Salli Pendergast
SSD-9439
PL/336/2018
22 October 2019

Property: 75 Warnervale Road, WARNERVALE
Description: Construction of a new Warnervale Public School
State Significant Development SSD-9439

Thank you for the opportunity to provide comments for the Environmental Impact Statement provided for the State Significant Development (SSD-9439) for a proposed New Warnervale Public School at 75 Warnervale Road at Warnervale.

Drawing Title
TREE REMOVAL PLAN

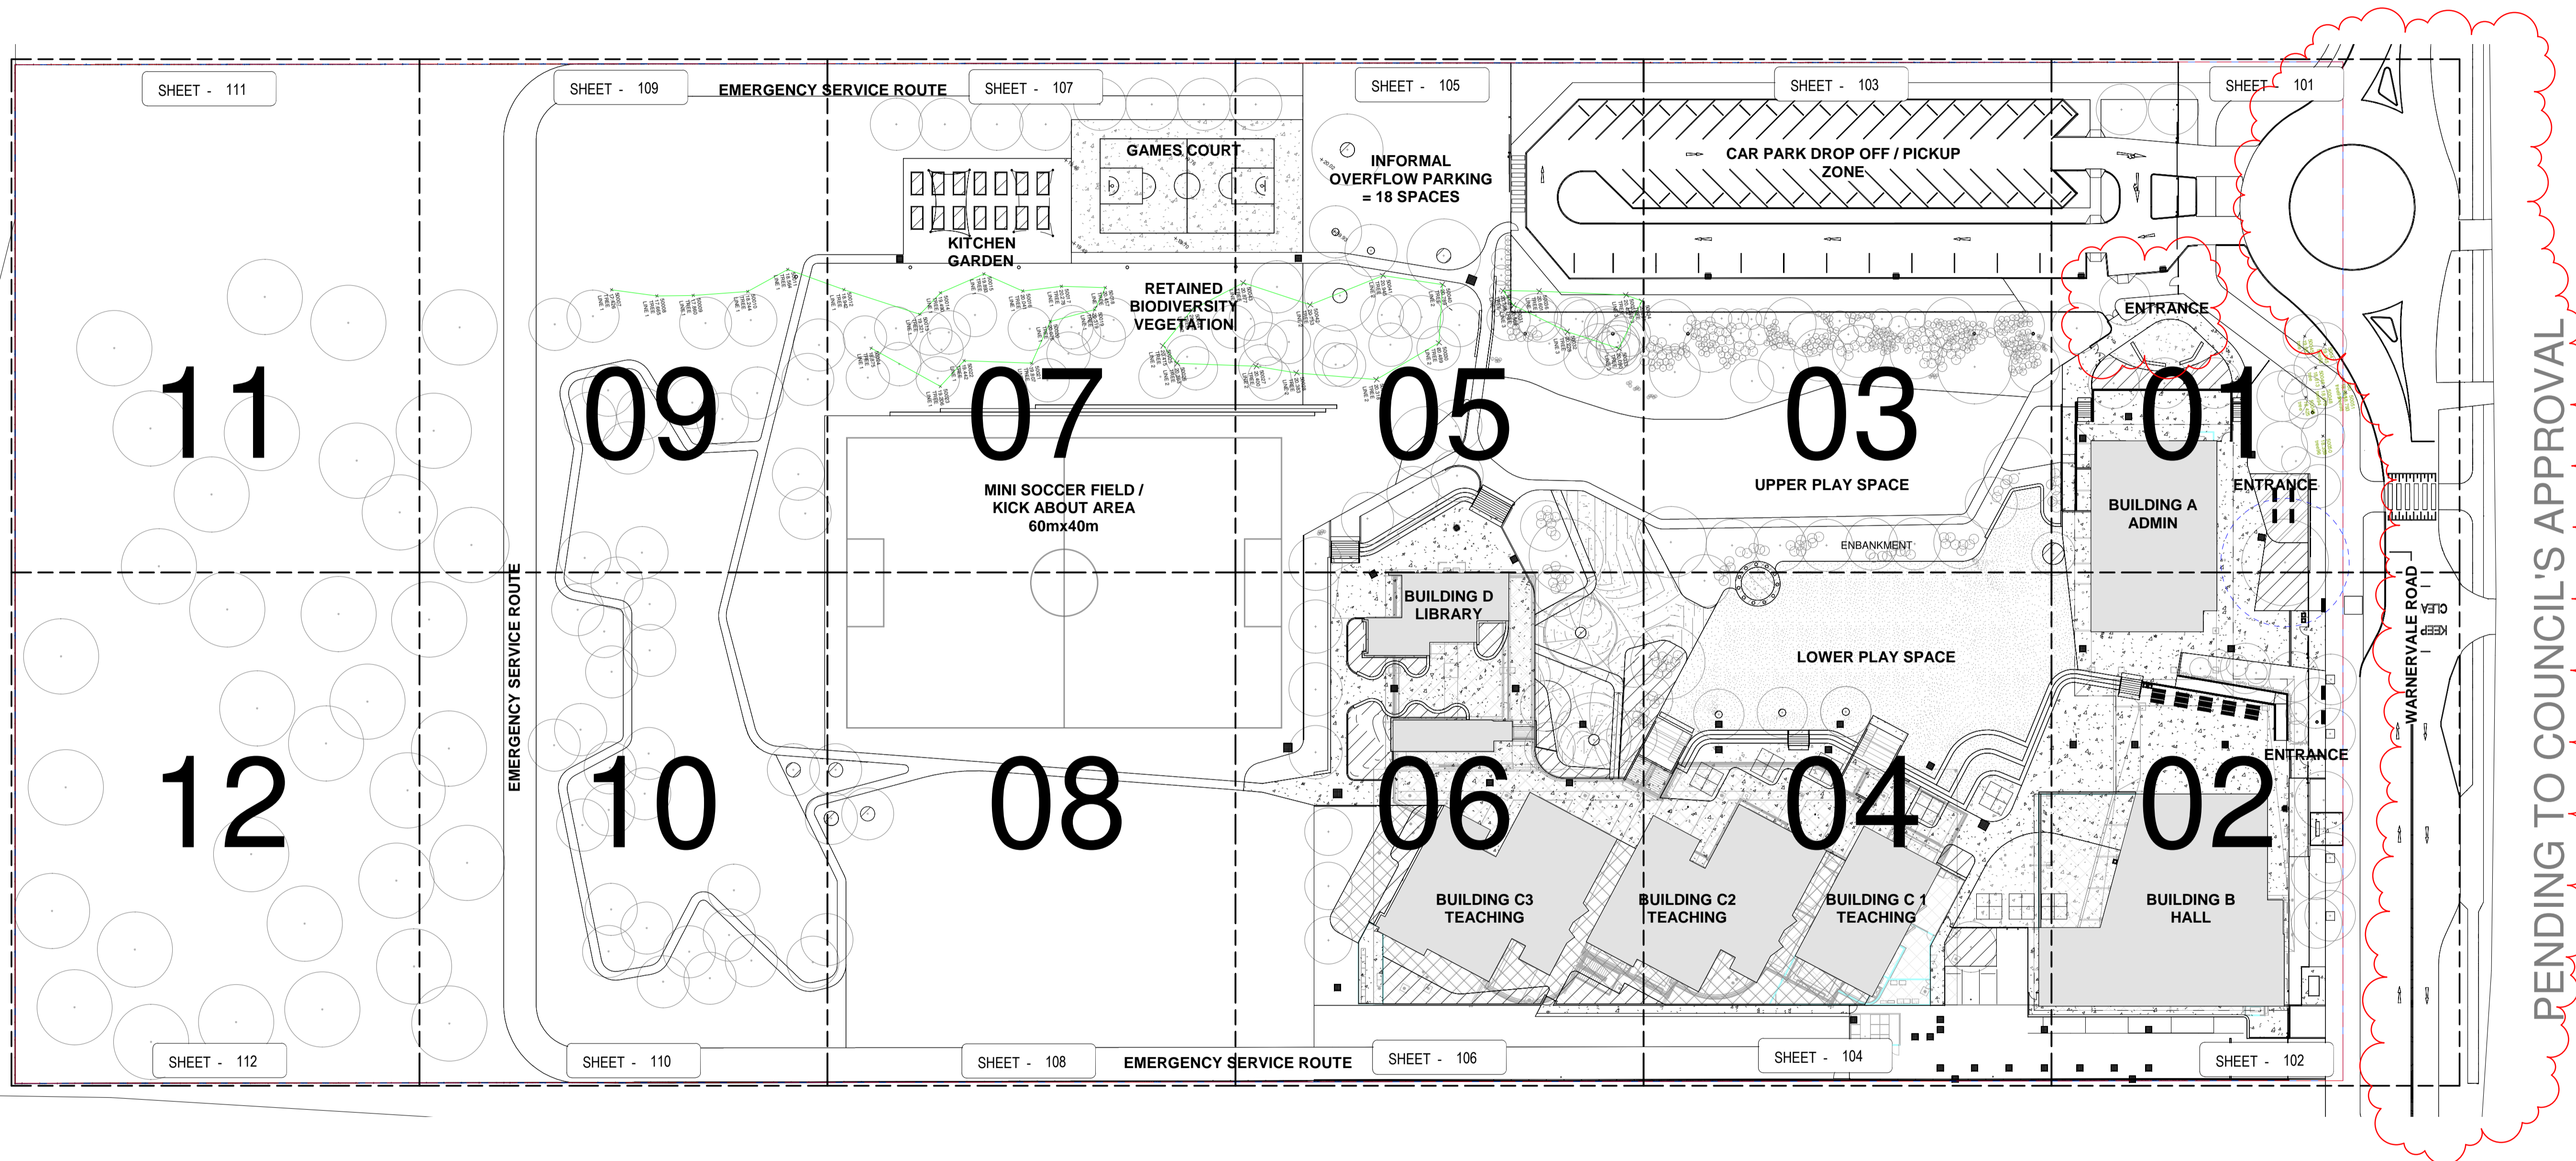
- 5 Concern is raised regarding the extent of tree removal associated with the proposal. Replacement native tree planting to compensate for the loss of trees along the street front, within the street setback and areas adjacent to the side boundary (within proximity and view of the street) should be investigated and carried out.

The street trees also provide for a linking corridor of vegetation across Warnervale Road which is being impacted under the proposal. The squirrel glider glides between trees and the species is sensitive to habitat fragmentation when tree gaps exceed its gliding ability.
